Our Case Number: ABP-317679-23

Re: Ringsend to City Centre Core Bus Corridor Scheme.
Ringsend to City Centre, Co. Dublin.

Ár dTag | Our Ref. TII23-124008

Re: BusConnects Ringsend to City Centre Bus Corridor Scheme

Drawing Title
RINGSEND TO CITY CENTRE CORE BUS CORRIDOR SCHEME
TRAFFIC SIGNS AND ROAD MARKINGS

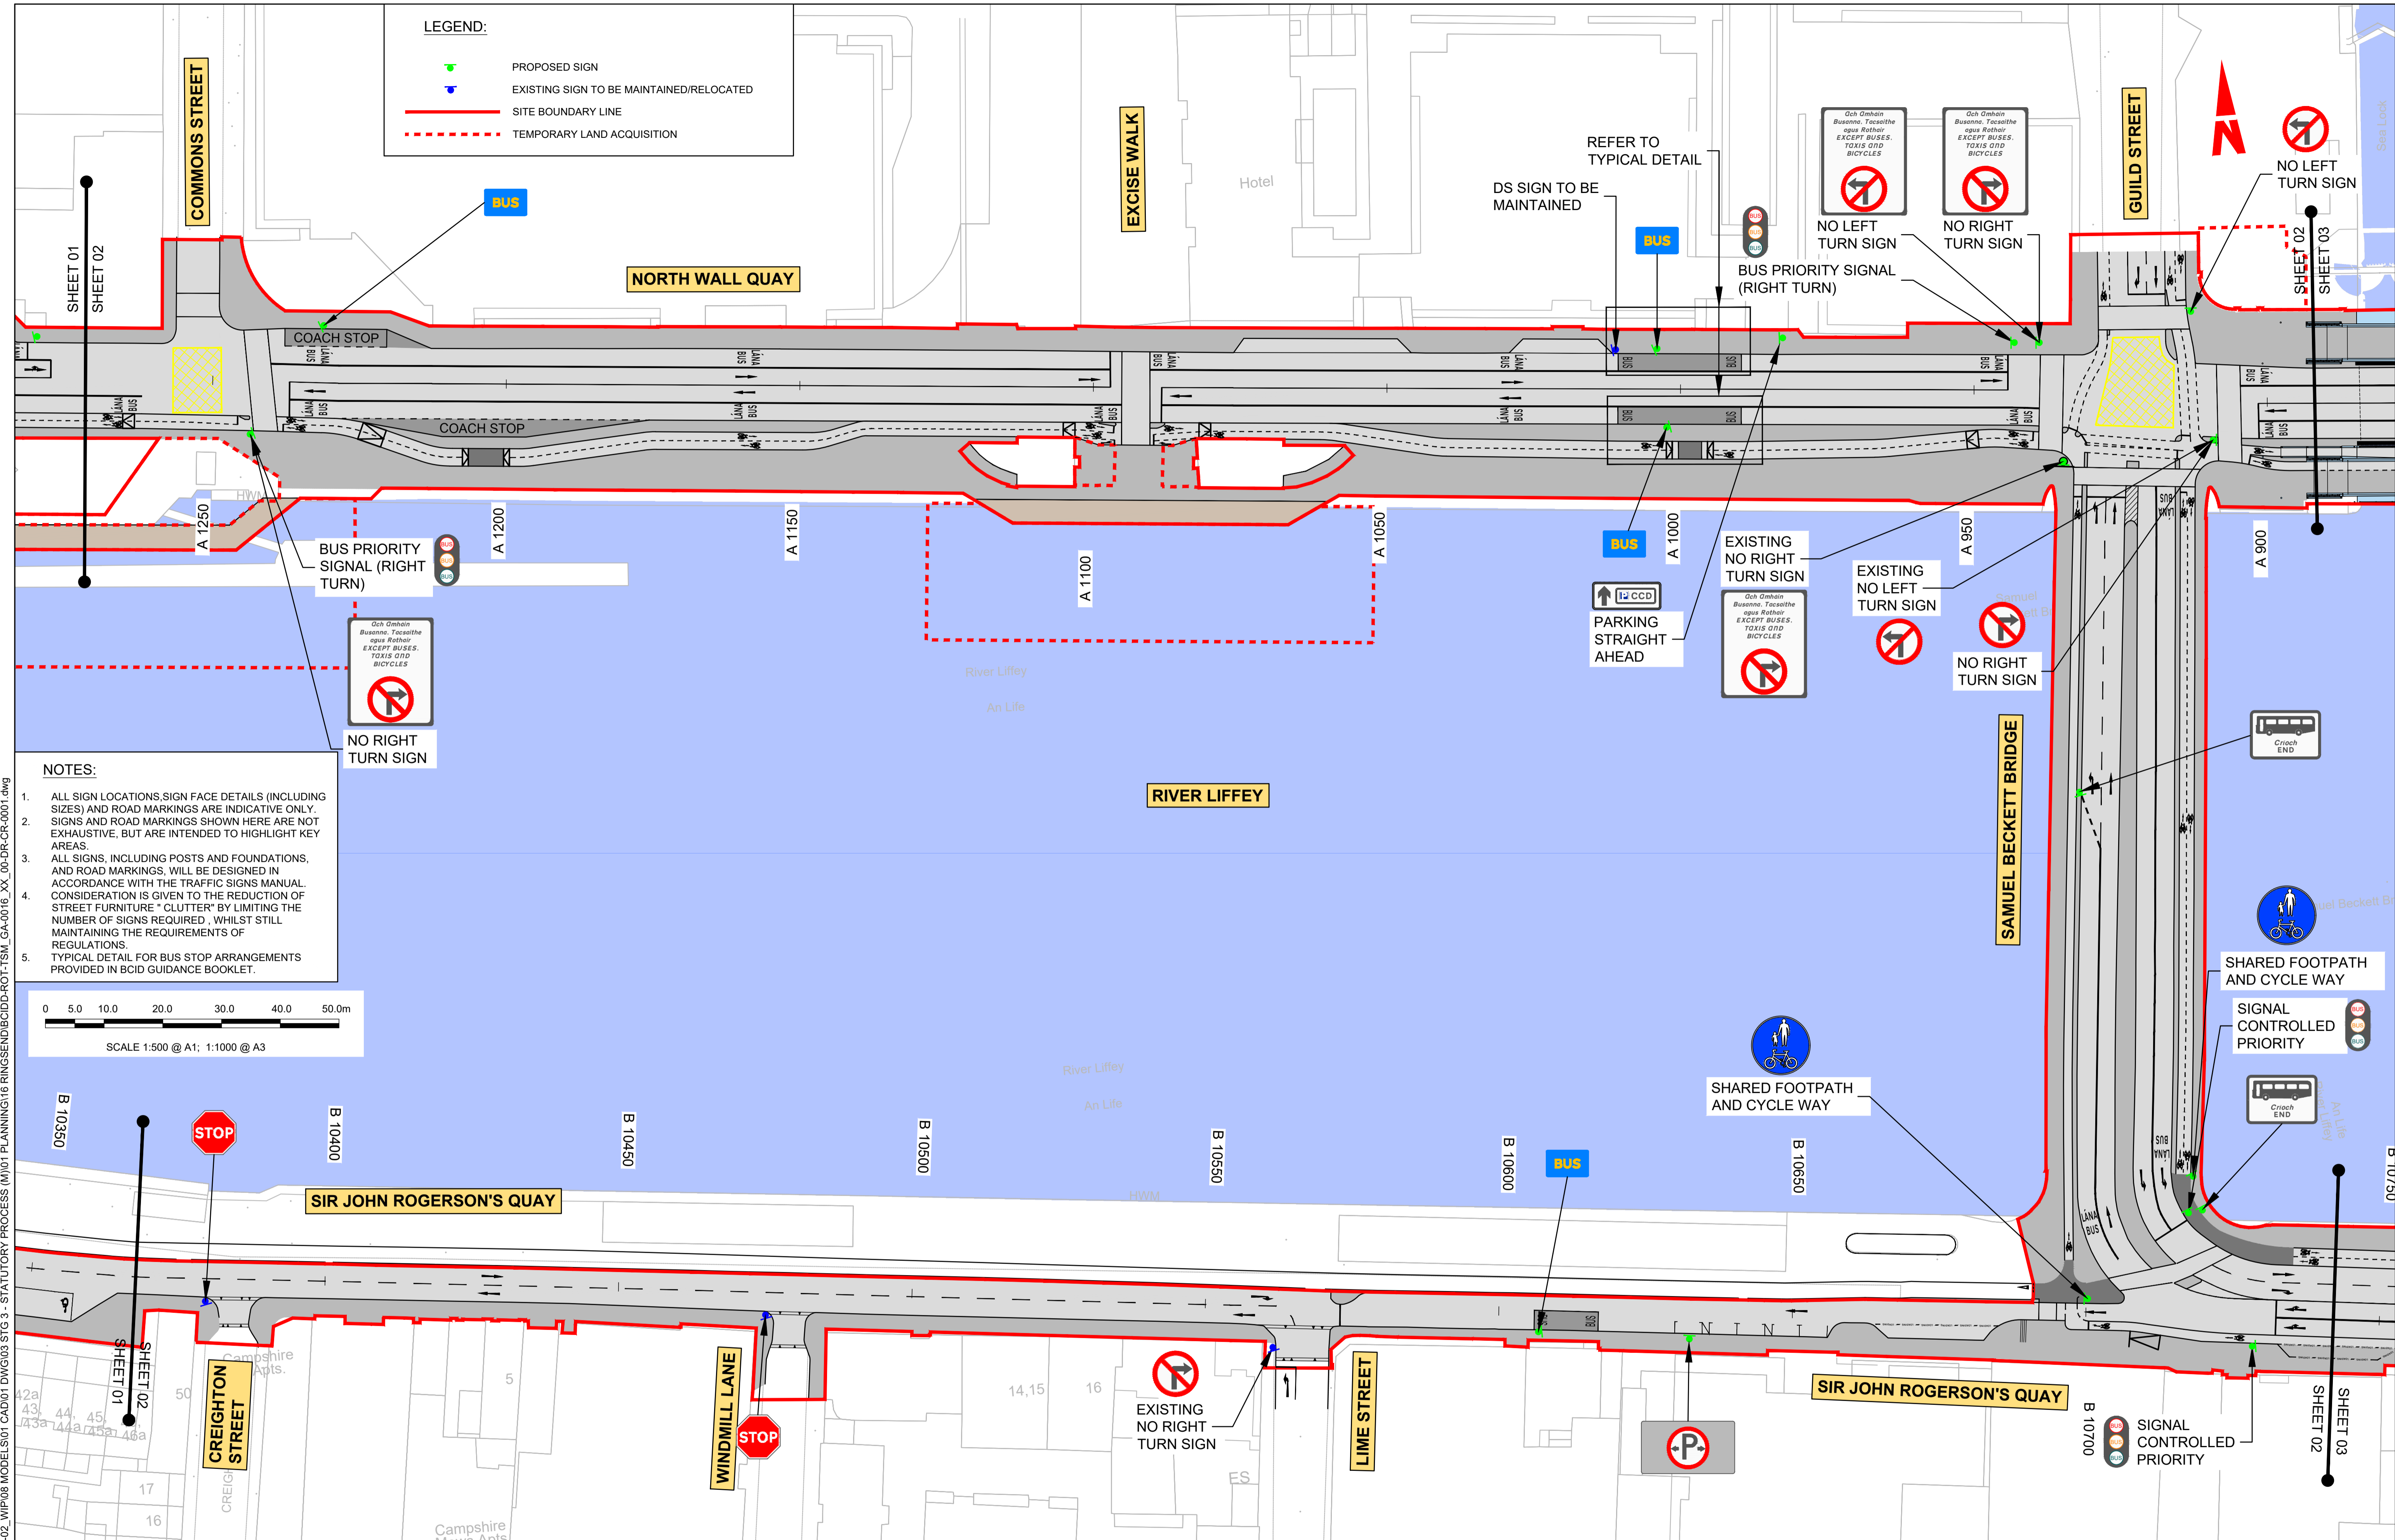
TII advise that this alteration is not indicated on *Ringsend to City Centre Core Bus Corridor Scheme Traffic Signs And Road Markings*, Sheet no. 03 of 12, Drawing No. BCIDD-ROT-TSM_GA-0016_XX_00-DR-CR-0003, REV M01 (insert). The alteration appears to be depicted on *Ringsend to City Centre Core Bus Corridor Scheme Junction System Design Mayor Street Upper / Park Lane*, Sheet 20 of 20, Drawing No. CIDD-ROT-TSM_SJ-0016_XX_00-DR-TR-0020, REV M01.
